Application no: H18-0571-15

Description: Proposed new dwelling

Location: 62 NEW ROAD
SUTTON BRIDGE
SPALDING
PE12 9RQ

PLANNING AMENDMENT

PROPOSED SITE PLAN 1:200.

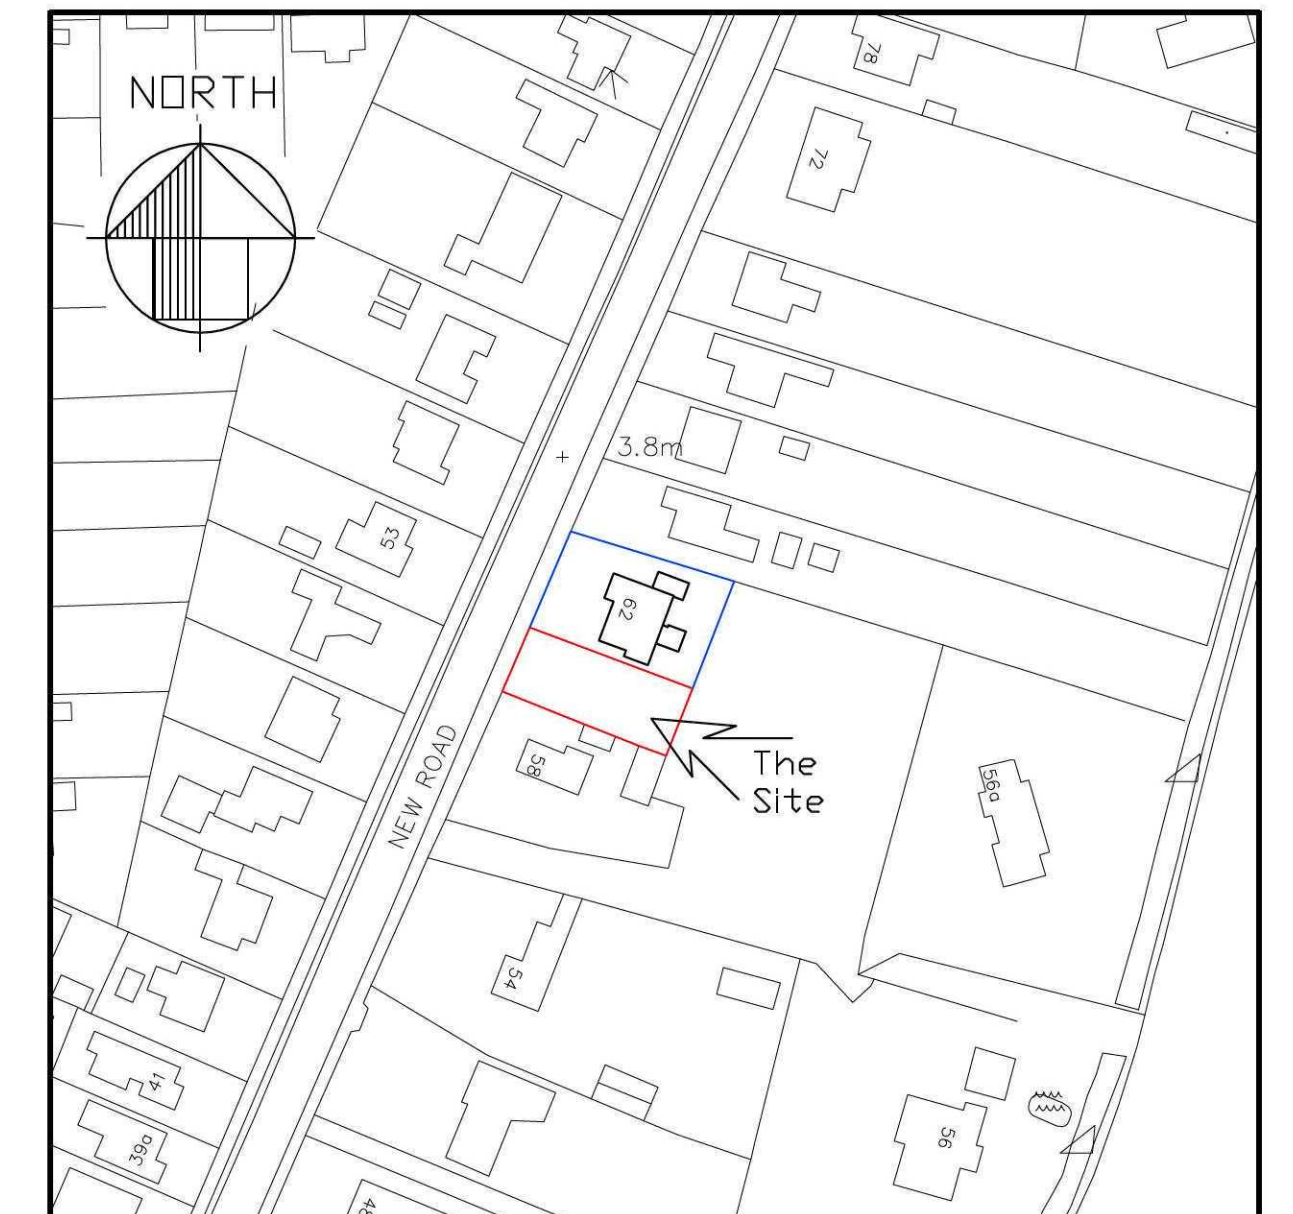
Amendment: Floor levels/buildings raised to suit Environment Agency requirements (dwgs 773-01d, 773-02b & Flood Risk Ass)

I refer to your recent e-mail and attach a completed amendment form together with the revised FRA for this project and amended drawings 773-01d & 02b that now show the ground floor level raised in accordance with EA's requirements.
